Our ref: 09/170-09

9 December 2015

**RE: Orica Southlands Remediation & Warehouse Development Project -  
Proposed Modification 3 (MP 06\_091 MOD3)  
– Flood Impact Assessment and Turning Head**

LONG SECTION - PIT B13 TO PIT B2

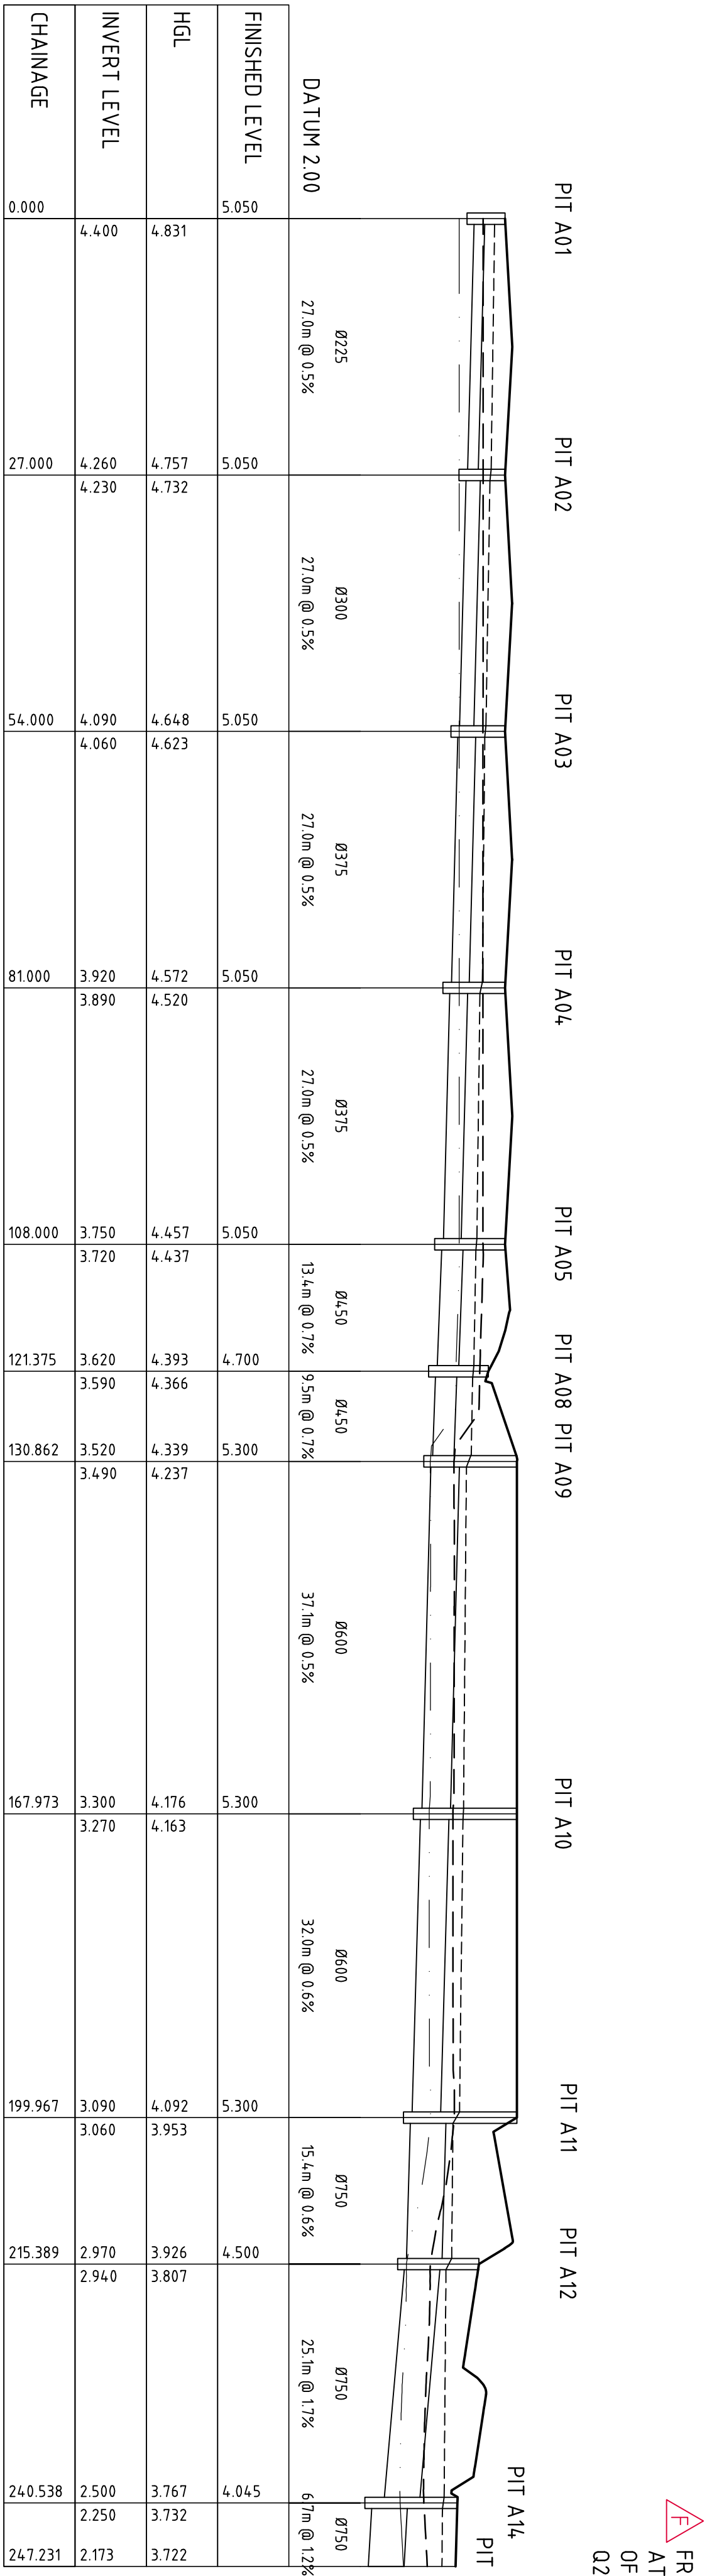
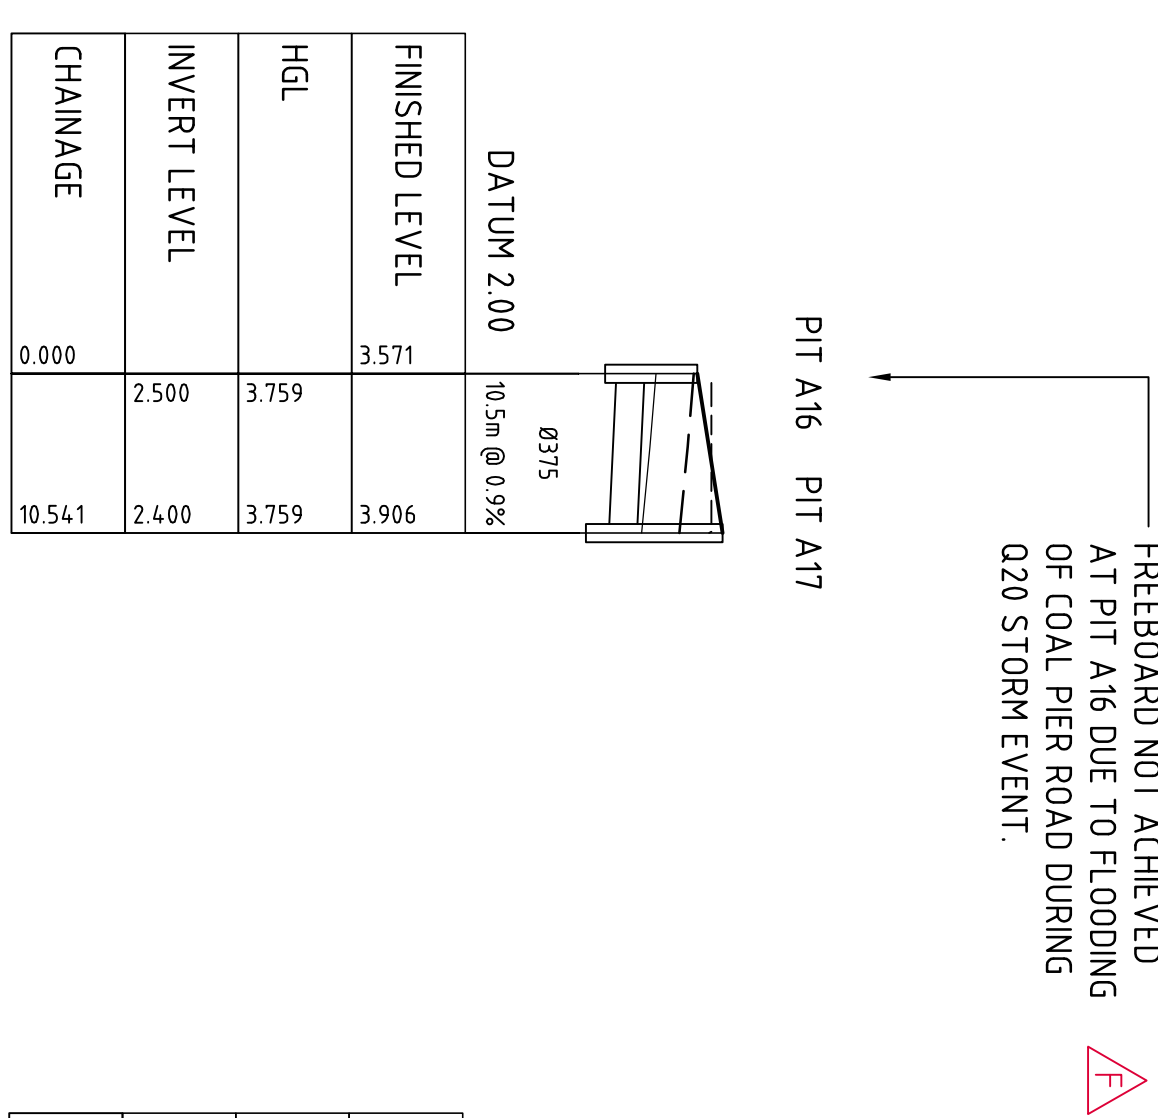
- Is there any overflow path considered from PIT B01 to OUTLET B2? If there is, it is not shown on the architectural plans.
- It is noted on the Site Plan that the rainwater tanks for Warehouse A and B have a capacity of 25kL. Please justify what roof area has been considered to determine the capacity.
- Is there any charged line cleanout pit designed for the rainwater tanks charged line?
